TfNSW Reference: SYD17/01529/11

DPIE Reference: SSD 8859

EXHIBITION OF AMENDED EIS FOR ELIZABETH DRIVE SUBDIVISION INCLUDING LEFT IN/LEFT OUT ACCESS ARRANGEMENT ON FUTURE REALIGNED WALLGROVE ROAD- 1111-1141 ELIZABETH DRIVE, CECIL PARK

TfNSW has reviewed the submitted documents and the concept plan of the proposed left in/left out access arrangement to the site from future realigned Wallgrove Road. Upon review of the documents, TfNSW requests the following information and amendments for further assessment of the development:

Figure 8 | Original detailed concept plan of roadway changes

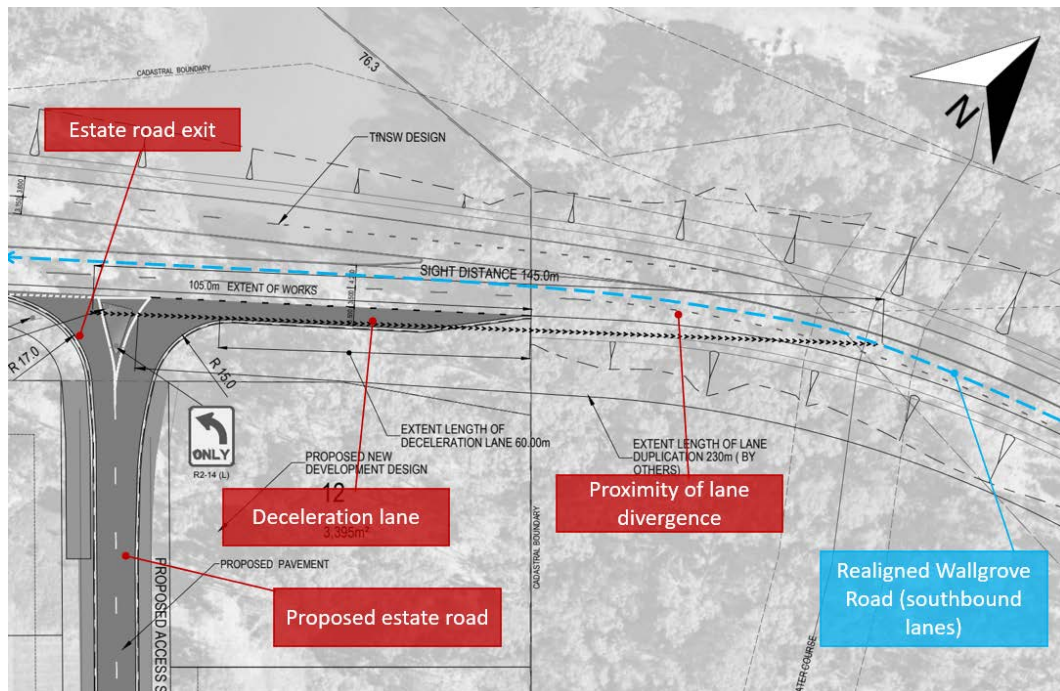
1. There is a safety issue of the arrangement of the development of the second kerb side lane and the proposed left turn deceleration lane.

Vehicles exiting the access road could confuse vehicles changing lanes to access the second kerb side lane with vehicles wanting to access the left turn deceleration lane and could lead to accidents. TfNSW requests that the development of the second lane be moved further back to the north in Wallgrove Road to the short straight between the reverse curves. The diverge should initiate from the centreline so vehicle continuing in the original lane is in lane one. The second lane should be fully developed prior to the second curve.

2. The length of the left turn deceleration lanes is too short for the design speed of Wallgrove Road. The design speed of Wallgrove as per design criteria for this section of Wallgrove Road is 70kph with a posted speed of 60kph. For a design speed of 70kph the length should be 70m (including taper) with a turn speed of 20kph.

3. Assuming that a second lane will be introduced prior to the auxiliary lane, the proponent will need to demonstrate that appropriate sight distances (AUSTROADS) are achieved to the C1 line.

A preliminary review of the design suggests this to be problematic. Note the design will be providing a G4 W Beam to protect the 2:1 batter. Given the downgrade on approach, the sight distance over the barrier may be achieved but this would need to be checked. To achieve compliance the length of auxiliary lane will need to be extended, else the verge and batter widened out which may result in works occurring outside of the project boundary.

4. The addition of the auxiliary lane will mean additional cutting into existing area which may compromise flood immunity. There is channel at the toe of the embankment. Widening out the carriageway for the auxiliary slip lane will mean that additional property acquisitions may be required as the earthworks associated with the channel will be outside of the project boundary. The same applies to the channel running further to the north- given the need to widen the carriageway to allow for the development of the second lane.
5. The 3x1500 diameter culverts will need to be extended to suit the widened formation.
6. The plan should be amended to remove all the chevroning in the entry and exit as it will get scrubbed out and it also entices pedestrians/cyclists to stand in the actual access.
7. The "No Access to Cecil Road" signs should be removed as it would be difficult to enforce.

8. It is not clear why turning path has been provided for a B-triple (35.4m). NSW Freight and Ports Plan used 30m Performance Based Standards (PBS 2B) combinations as the target vehicles. The use of the B-triple requires the access to be wider than needed and lengthens the crossing distance for active transport users. As previously advised, PBS 30m vehicle should be used as checking vehicle.
9. The proponent is requested to update the plans and annotate with some dimensions; lane widths, path width. Information on the RT bay and whether it is of sufficient length should be confirmed.
10. The design shows the continuation of a shared user path past the intersection of the DA site. The current intent is not to continue this further to the North. The
